Please ask for: Ms Iqraa Malik
Email: iqraa.malik@terraquest.co.uk
Telephone: 0121 234 1390
Our Ref: FP/251/21/PL
Your Ref:
Date: 22nd November 2021

Application for Planning Permission

Development: Erection of single storey rear extension following the demolition of existing lean to.
Location: 5 Davenport Road Felpham PO22 7JP

DATE	REVISION	BY
5 Davenport Road Felpham Bognor Regis West Sussex PO22 7JP		
DRAWN RD	CHECKED	
SCALE 1:50	DATE 01.01.22	
PROJECT TITLE Proposed Extension to 5 Davenport Road		
DRAWING TITLE Existing Ground Floor Plan		
DWG NUMBER 001		REV
NEG NUMBER

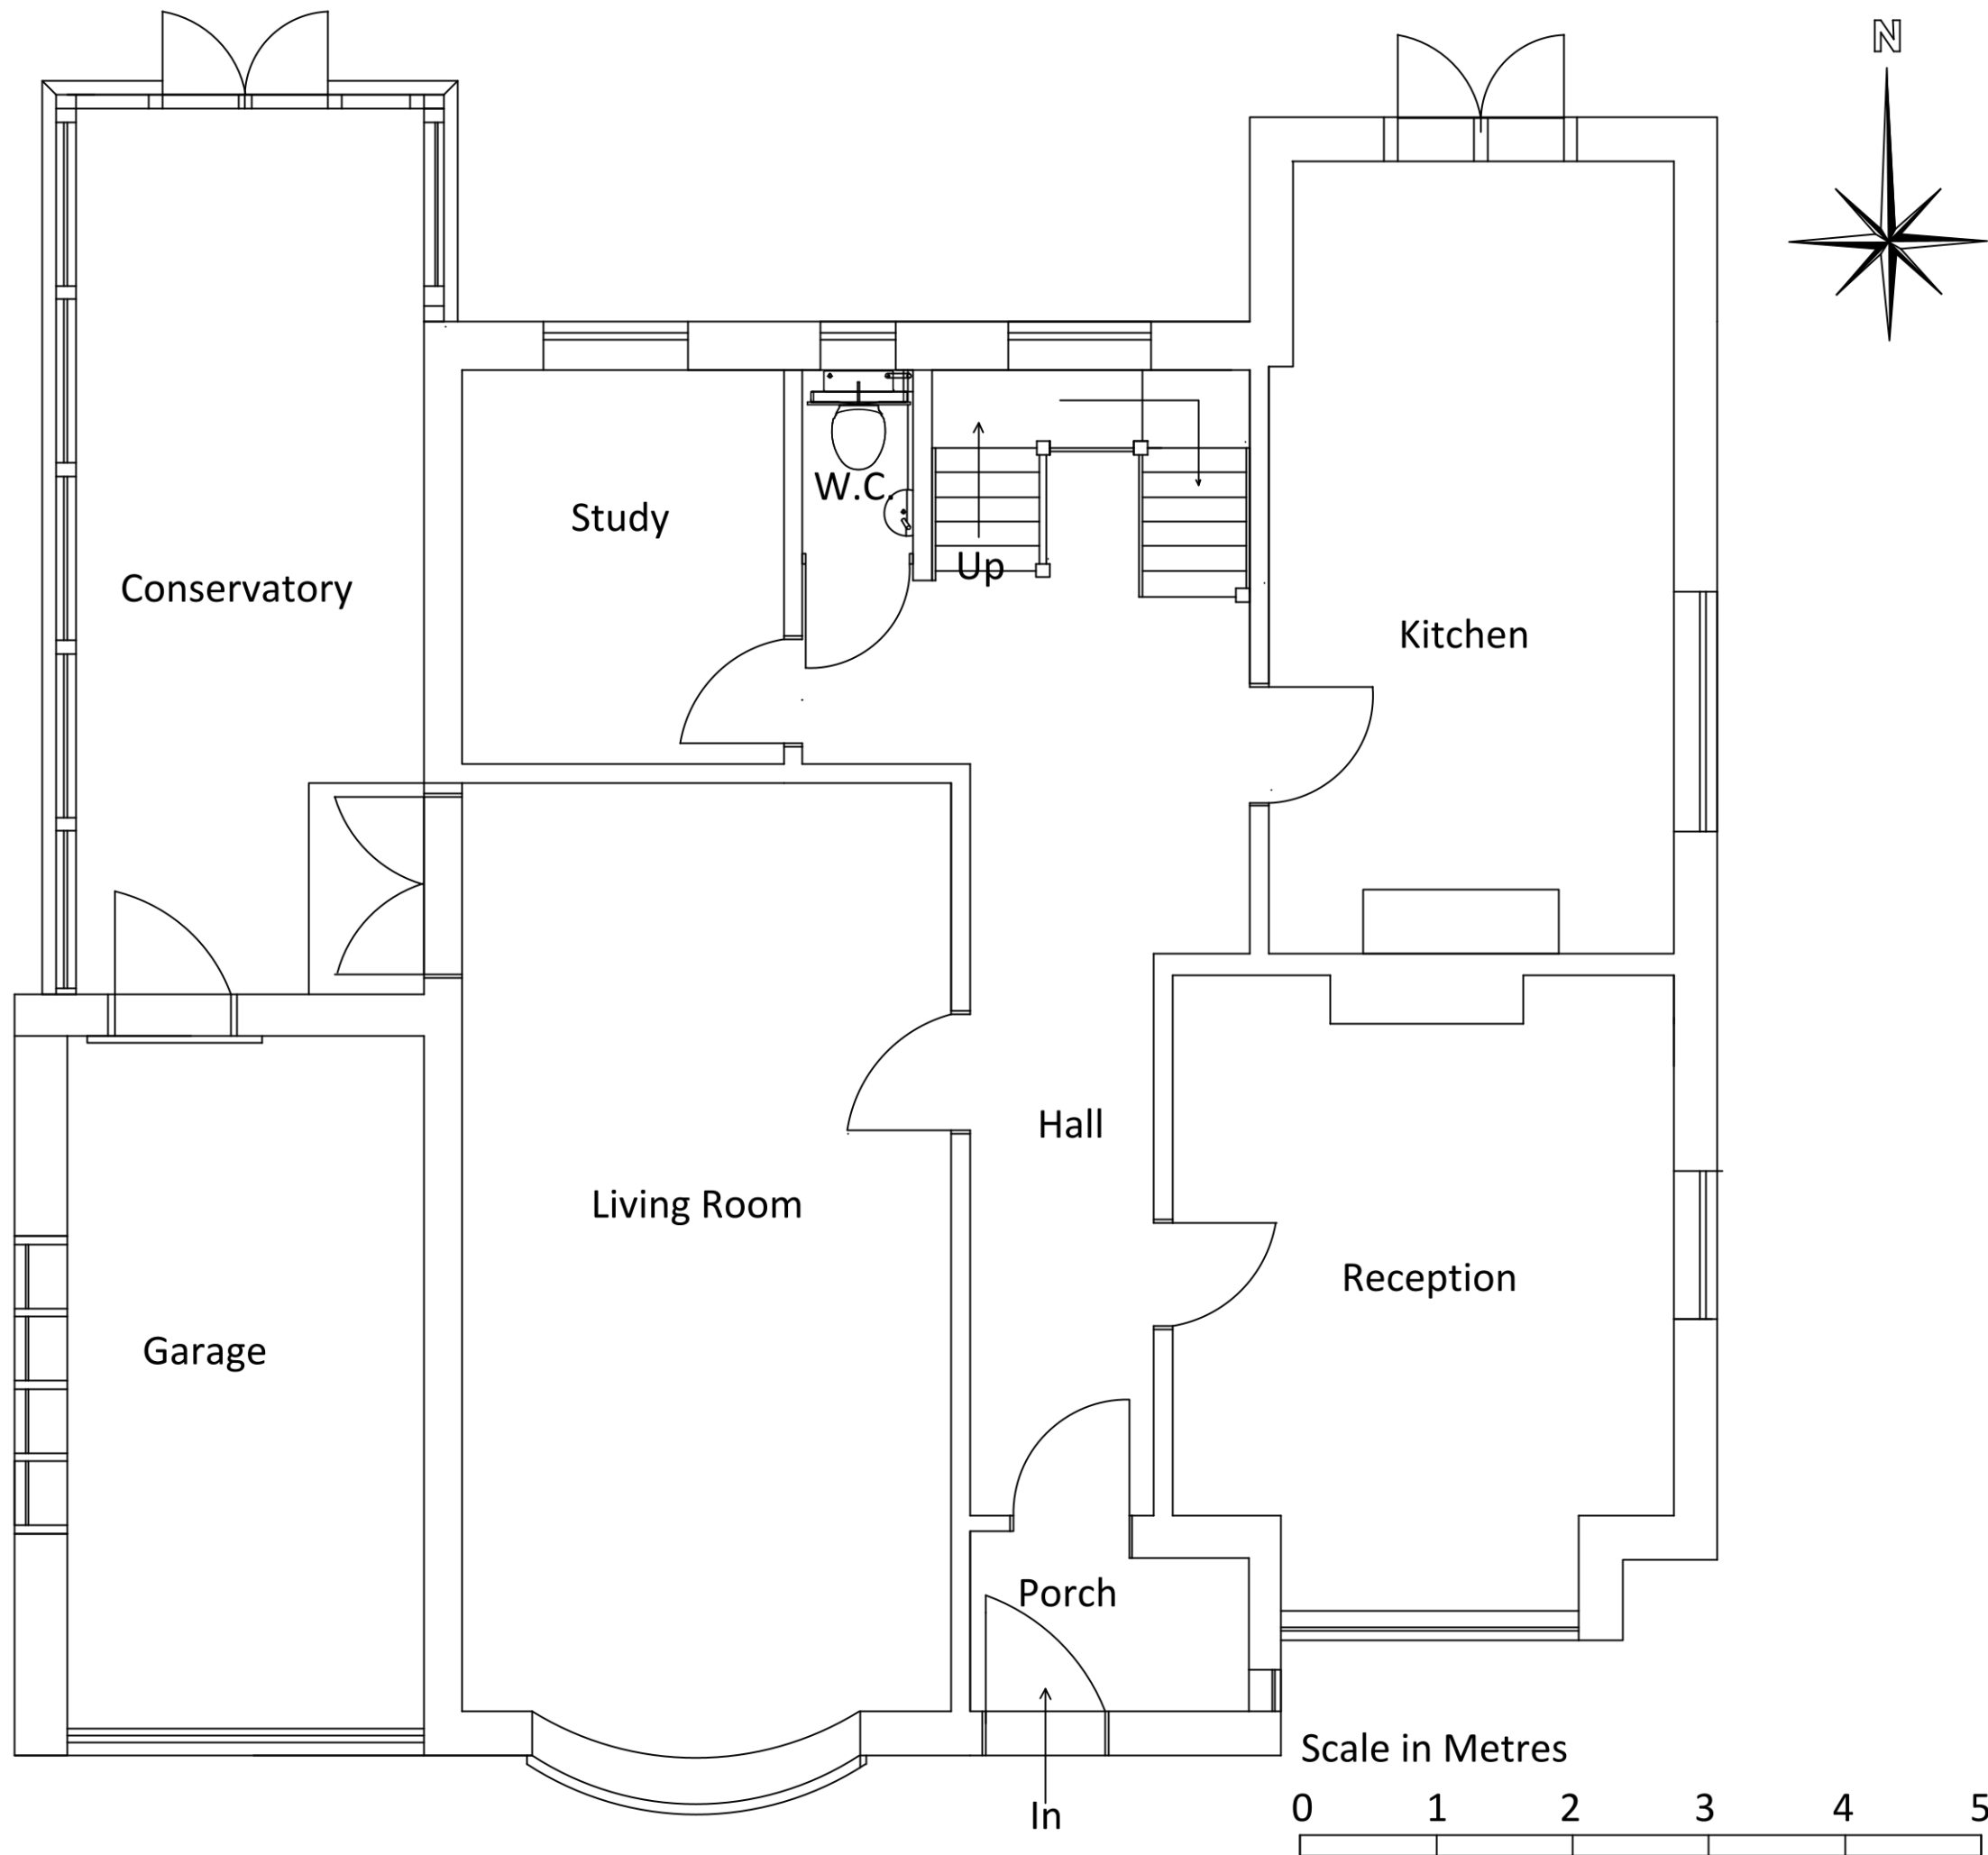
Please submit clearly labelled existing floor plans and elevations at a scale of 1:50 or 1:100. Further details can be found in the Validation Requirements List.

LOCATION PLAN

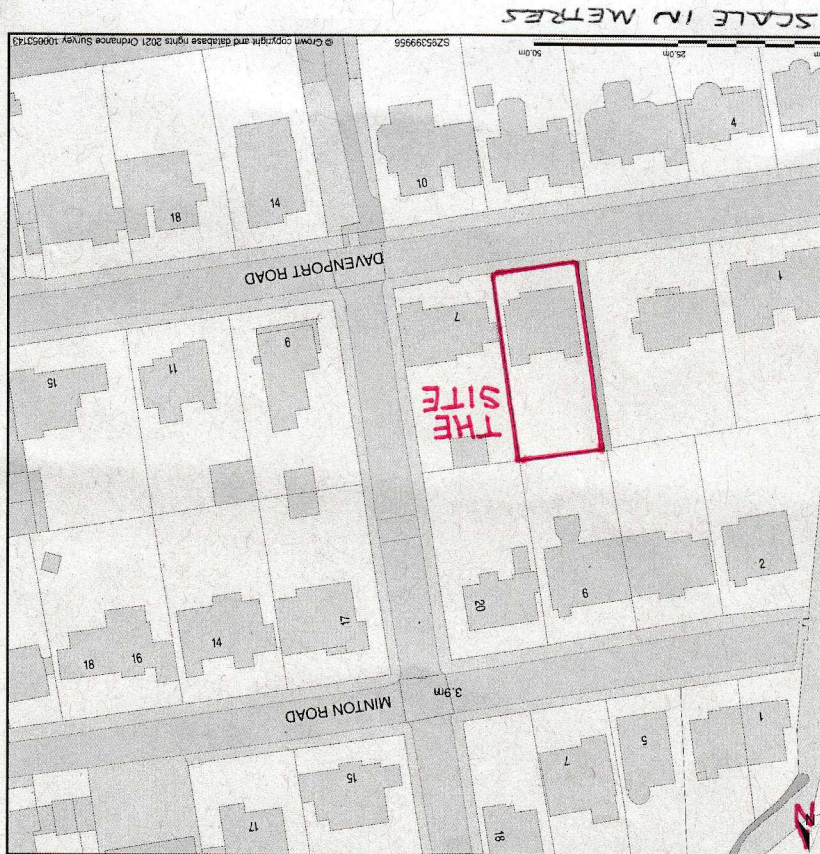
The location plan requires a solid red outline around the site boundary. Further details of what must be included on the plan can be found in the Validation Requirements List.

DATE	REVISION	BY
5 Davenport Road Felpham Bognor Regis West Sussex PO22 7JP.		
DRAWN RD	CHECKED	
SCALE 1:50	DATE 06.01.22	
PROJECT TITLE Proposed Extension to 5 Davenport Road		
DRAWING TITLE Proposed East Elevation		
DWG NUMBER 007	REV	
NEG NUMBER

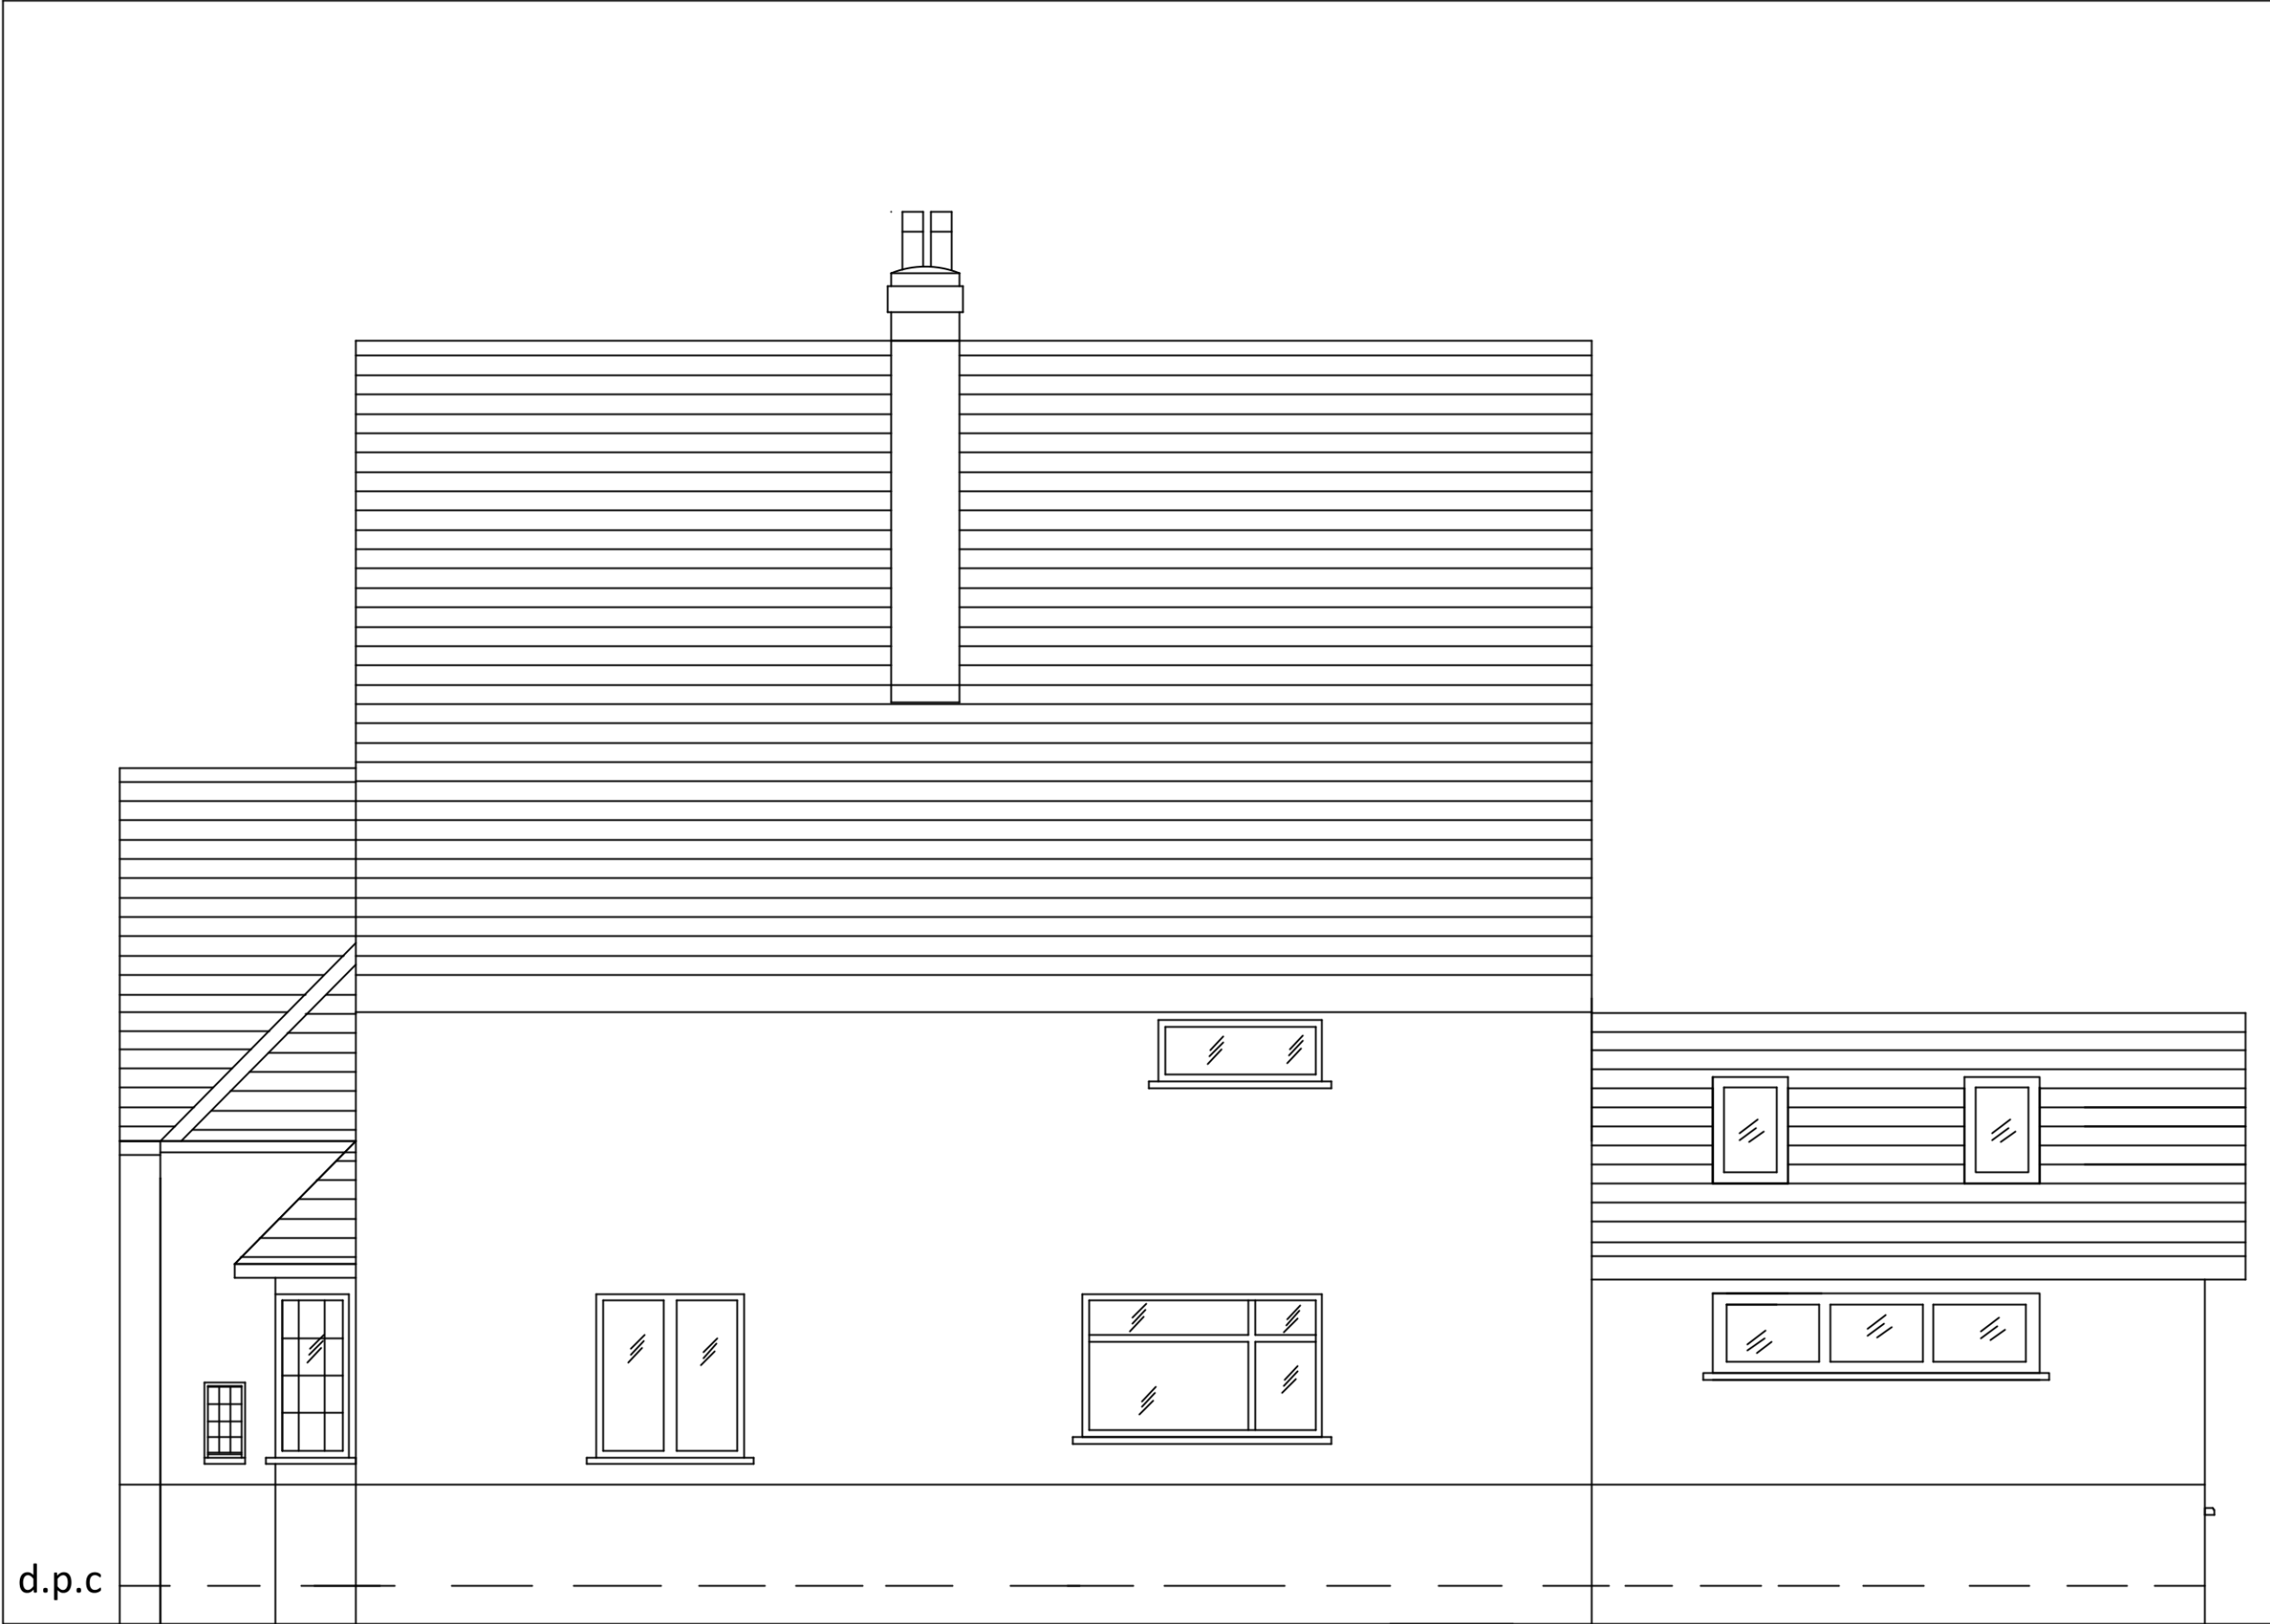
Please submit proposed elevations at a scale of 1:50 or 1:100. Along with this, the proposed floor plans require a stated scale. Further details can be found in the Validation Requirements List.
